Thank you for your email forwarding Council's final comments regarding the Nadine Street S75W, dated 14 March 2017.

Road Reserve Width

TYPICAL 5m ROAD 01 CROSS SECTION
SCALE 1:50

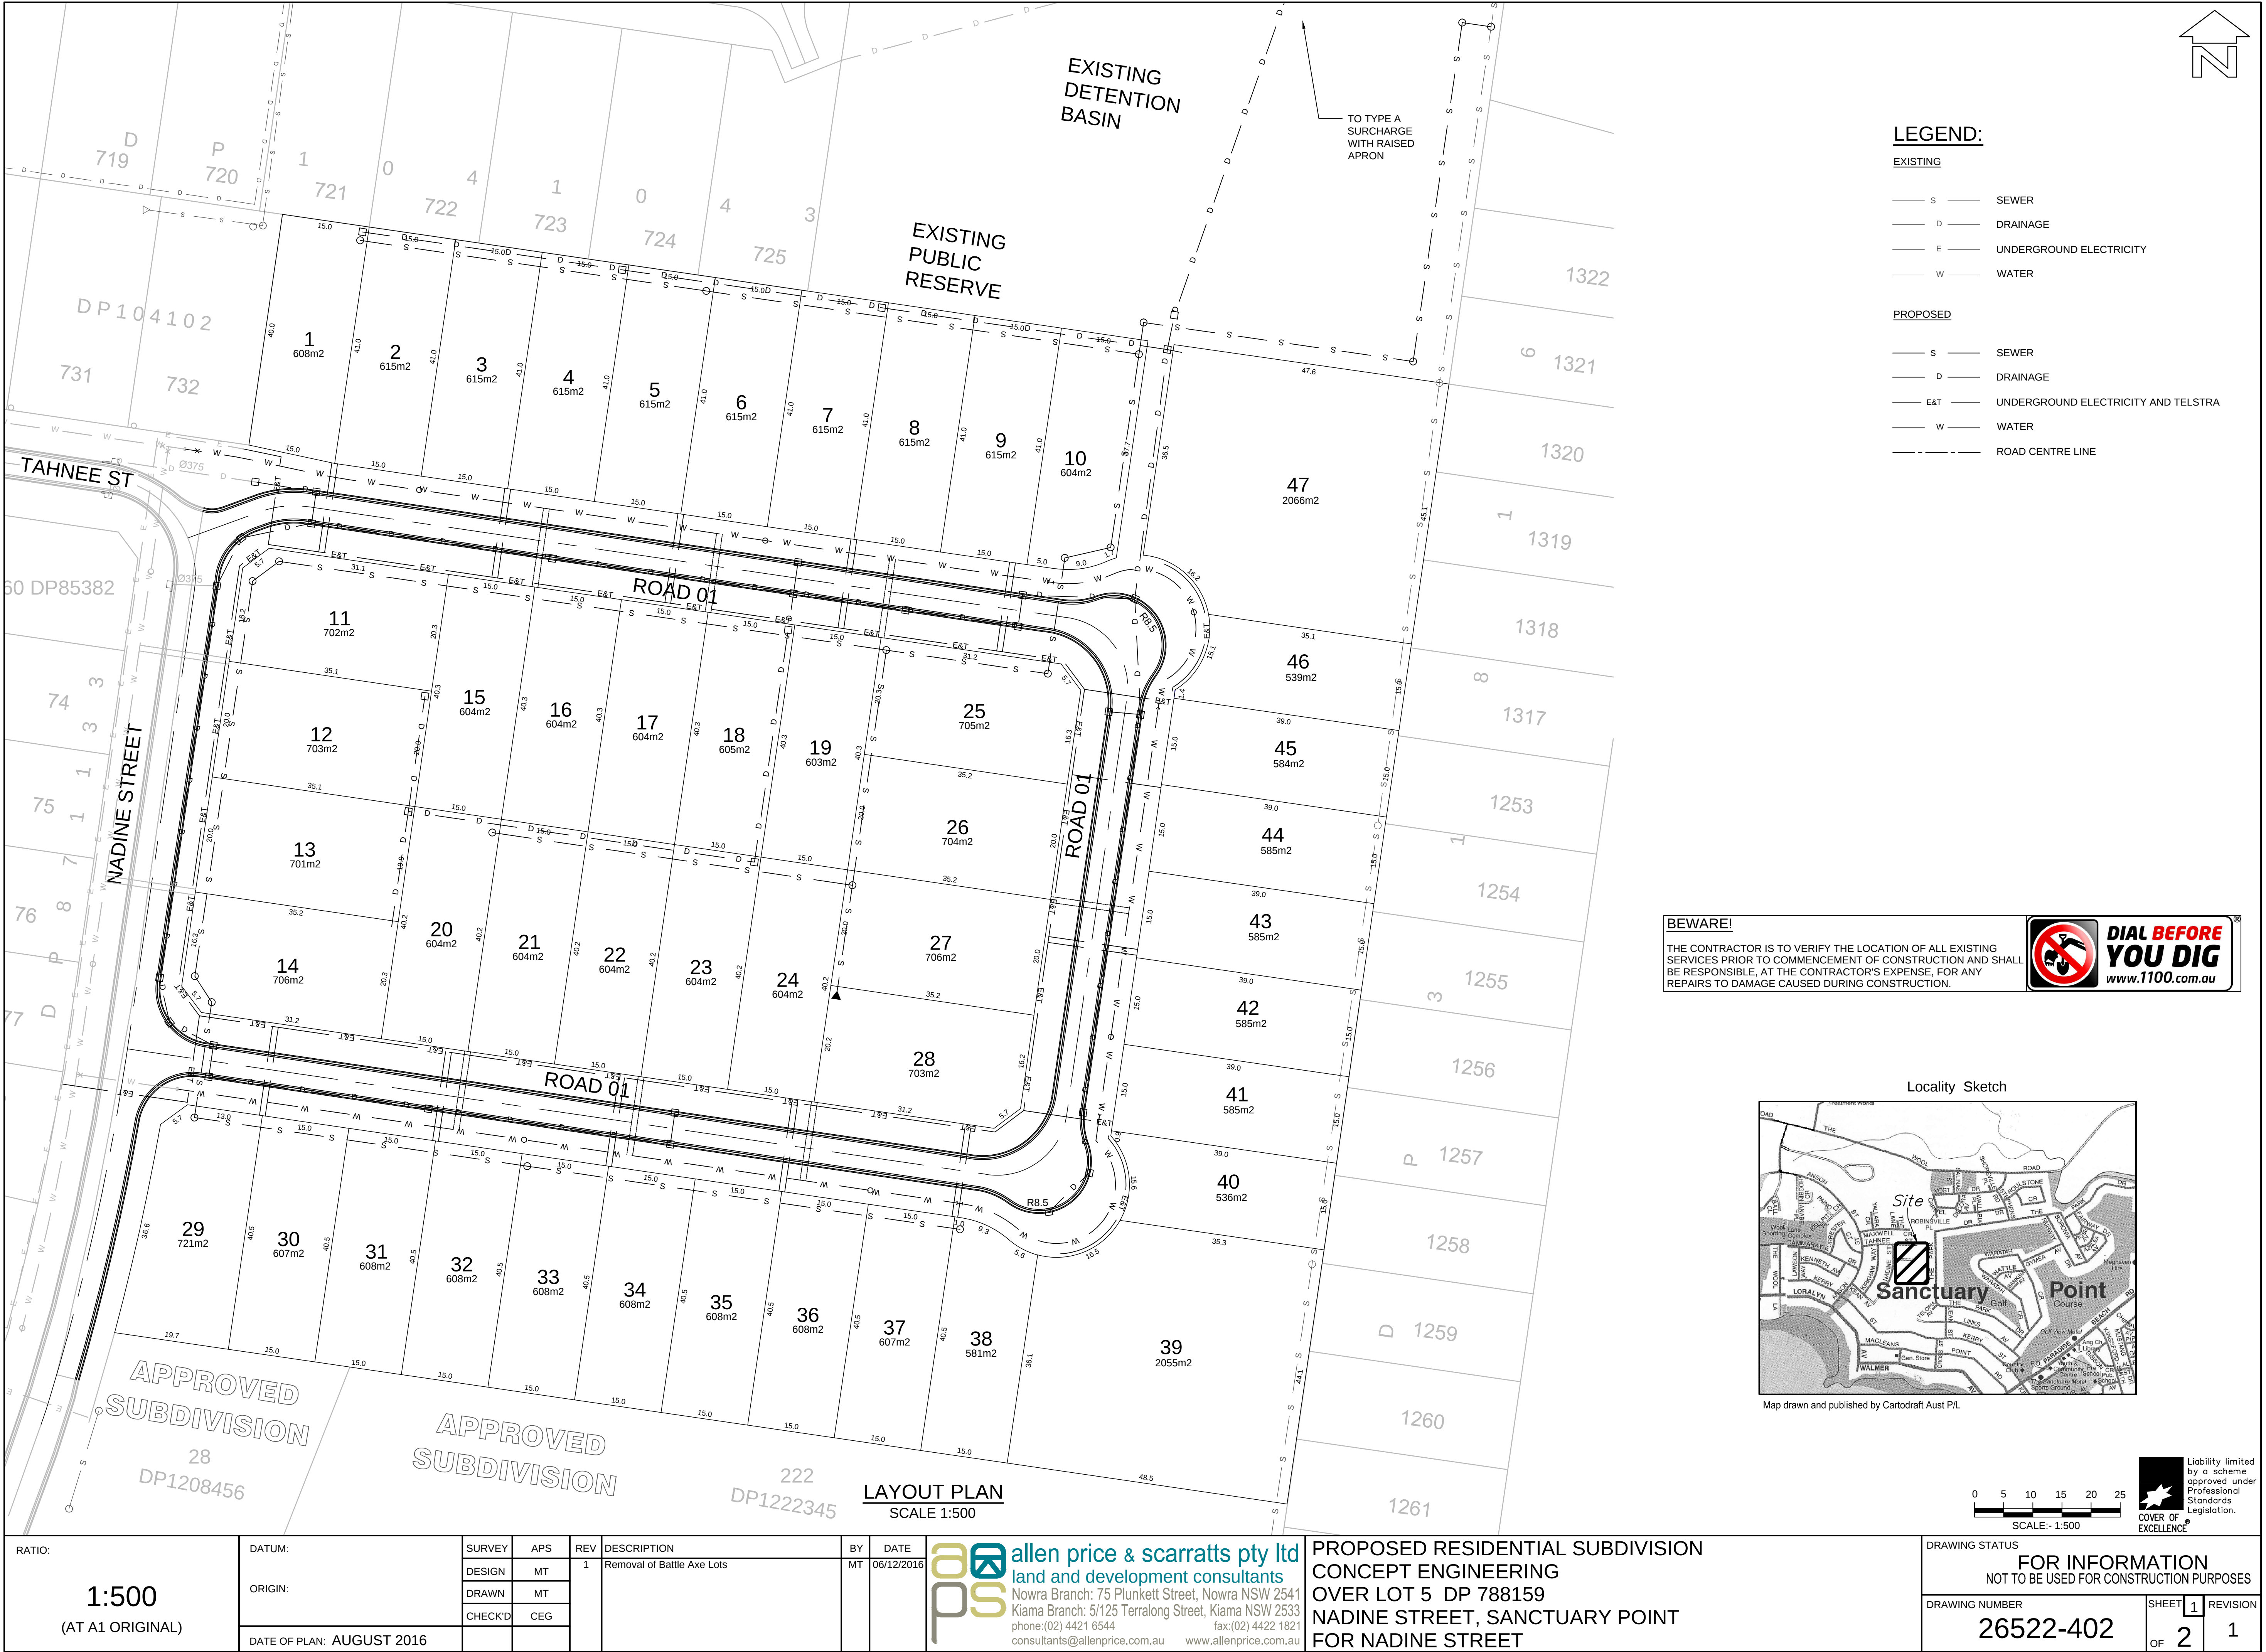
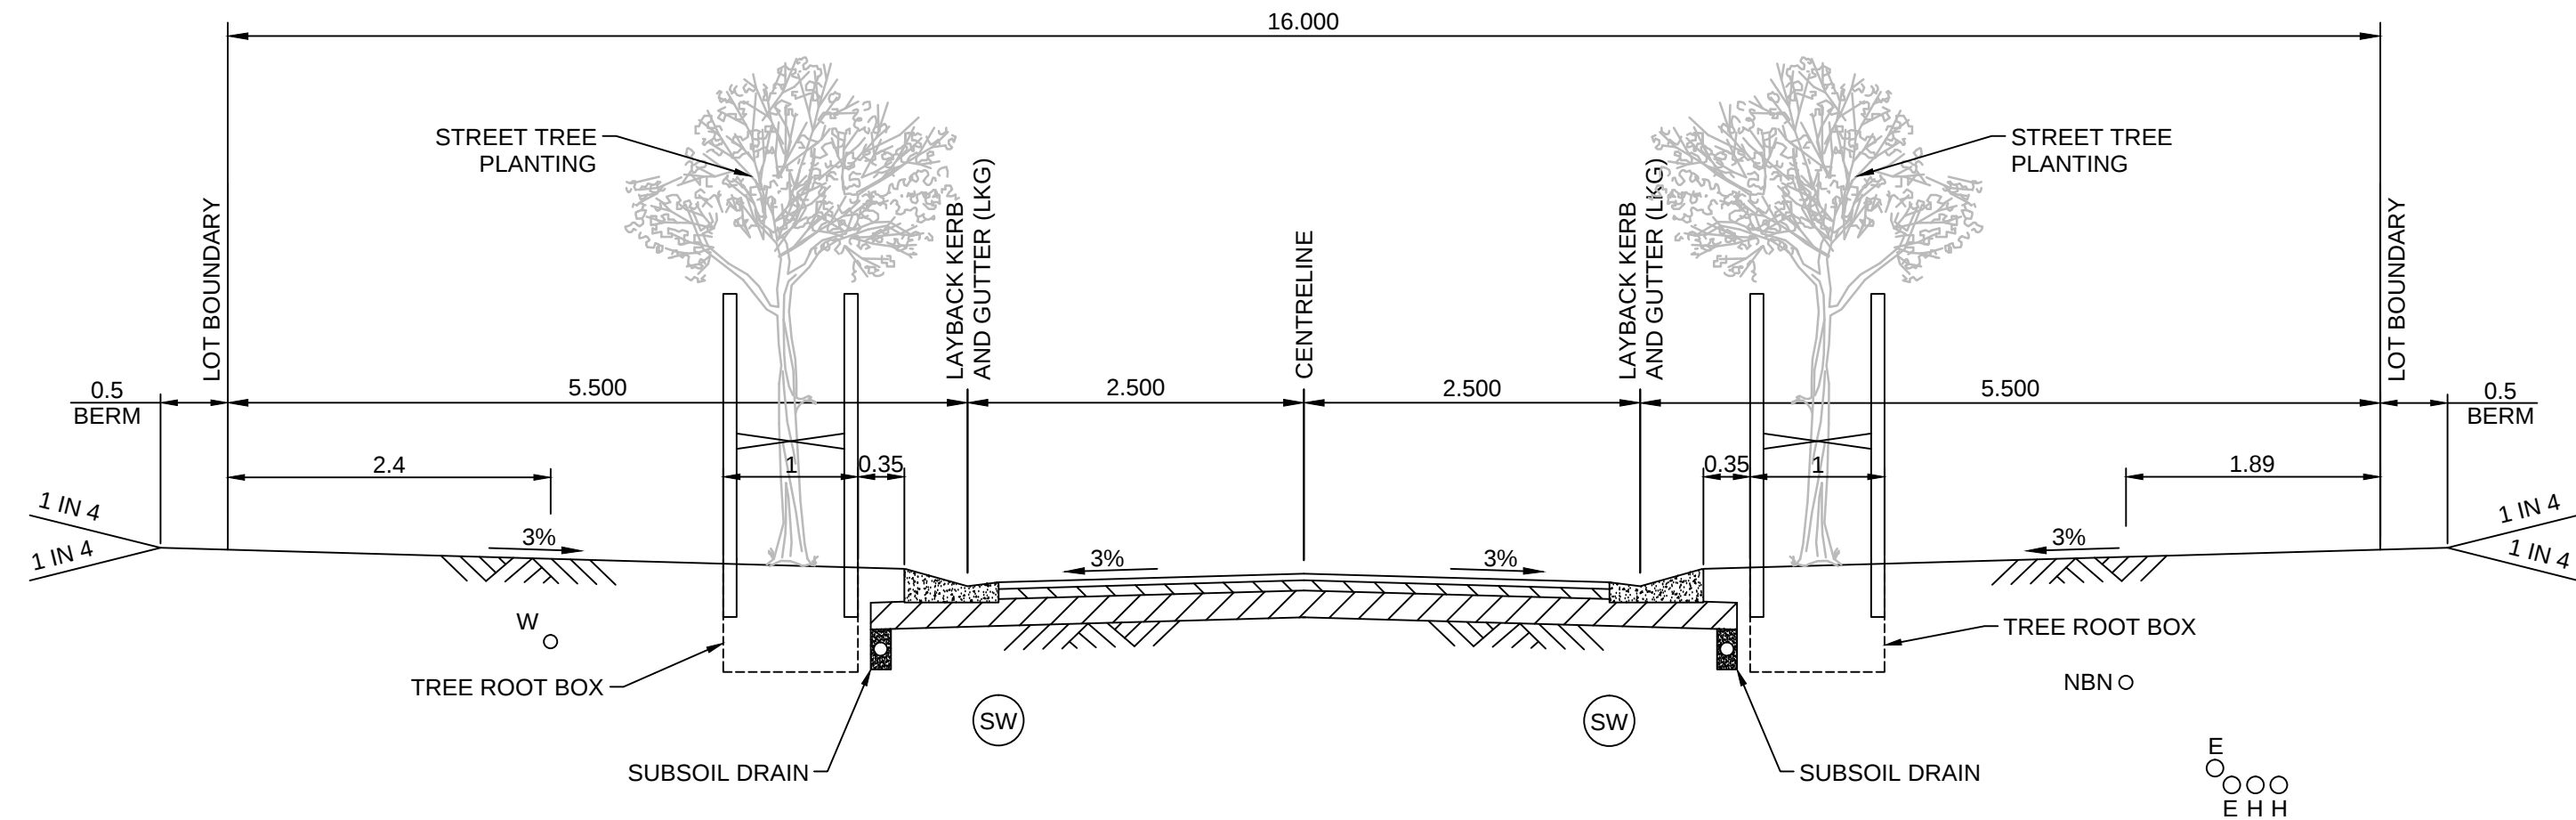
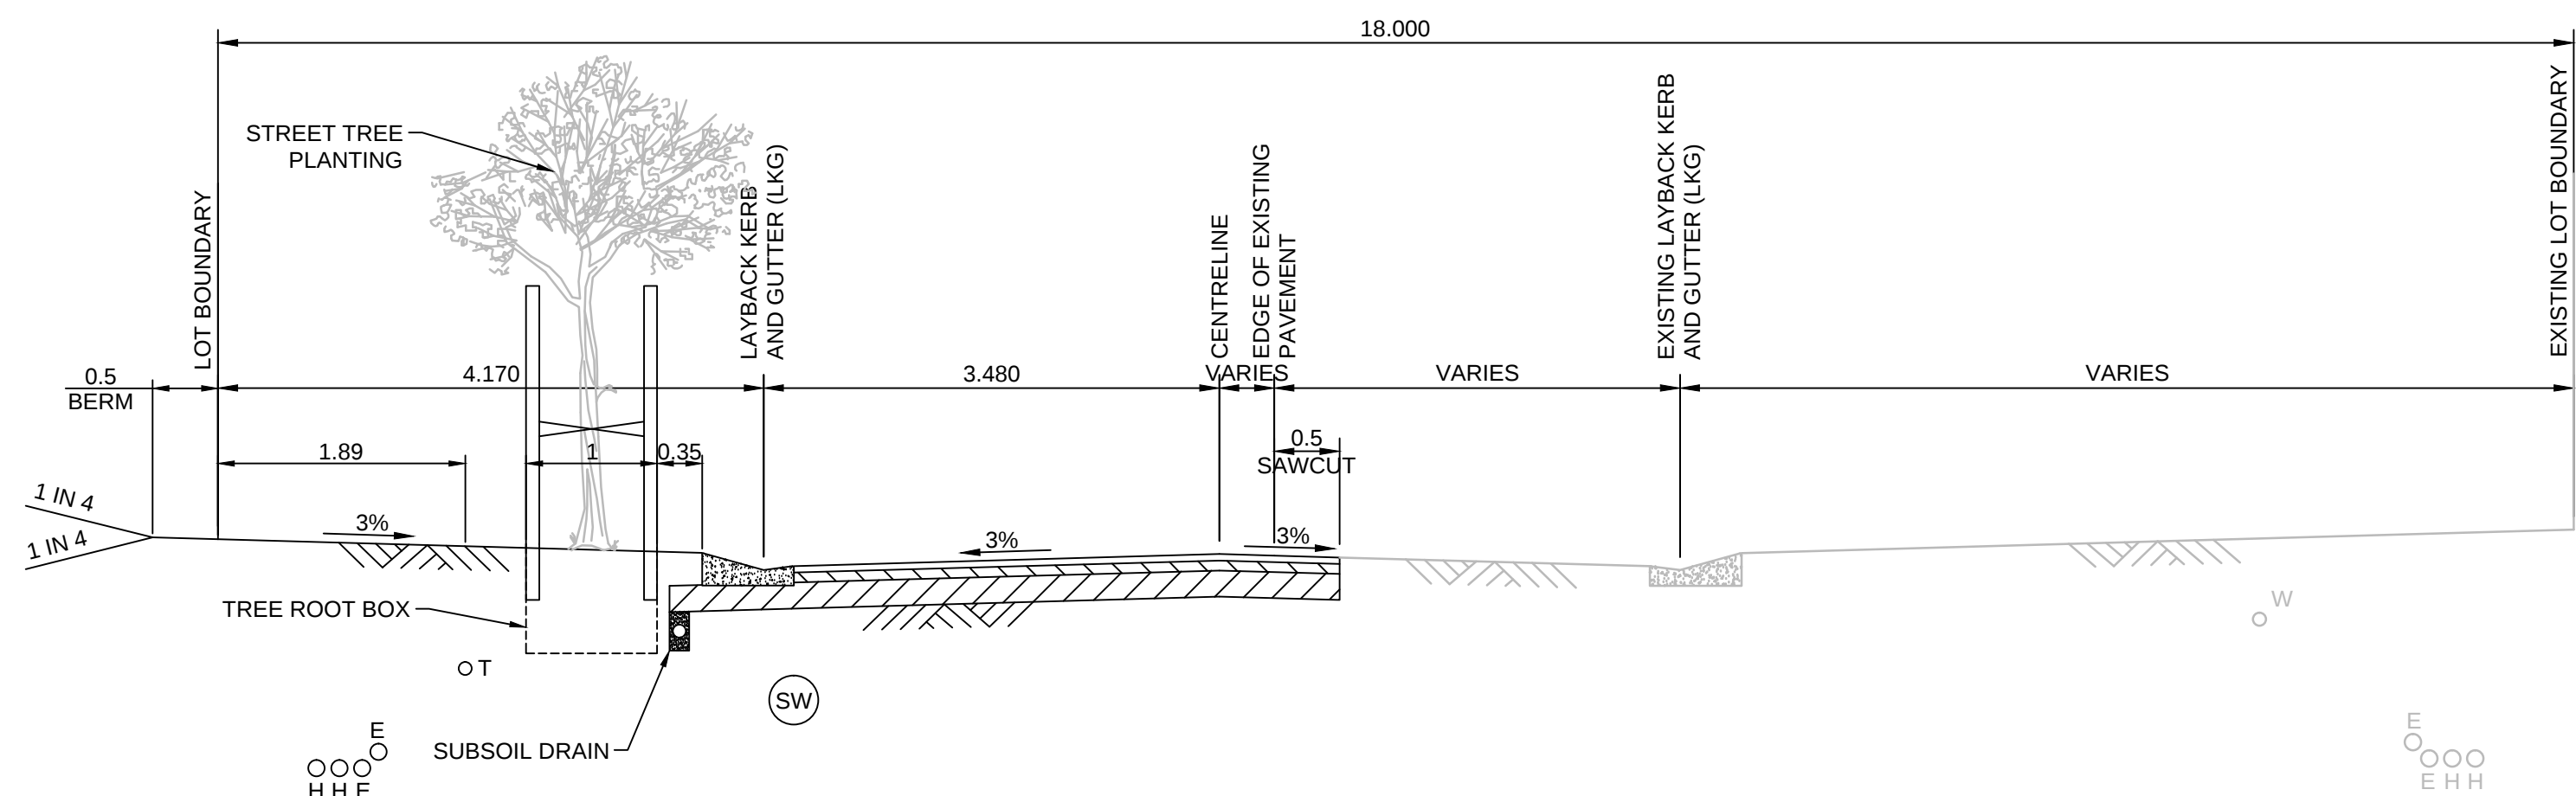
The proposed road reserve widths remain consistent with the requirements of the DCP. Council's Engineering Design Specifications provide details of a "typical cul-de-sac", shown as an access street, however, there is no requirement that an access street must be a cul-de-sac.

The DCP defines an access street as the following; *'Access streets generally are streets where the residential environment is dominant, traffic is subservient, speed and volume are low and pedestrian and cycle movements are facilitated'*. Given that the subject street is defined as an access street, there is no formal requirement for the road reserve to be 18m, and therefore it is proposed that the road reserve remain at the width of 16m.

No change to the 5m road carriageway is proposed.
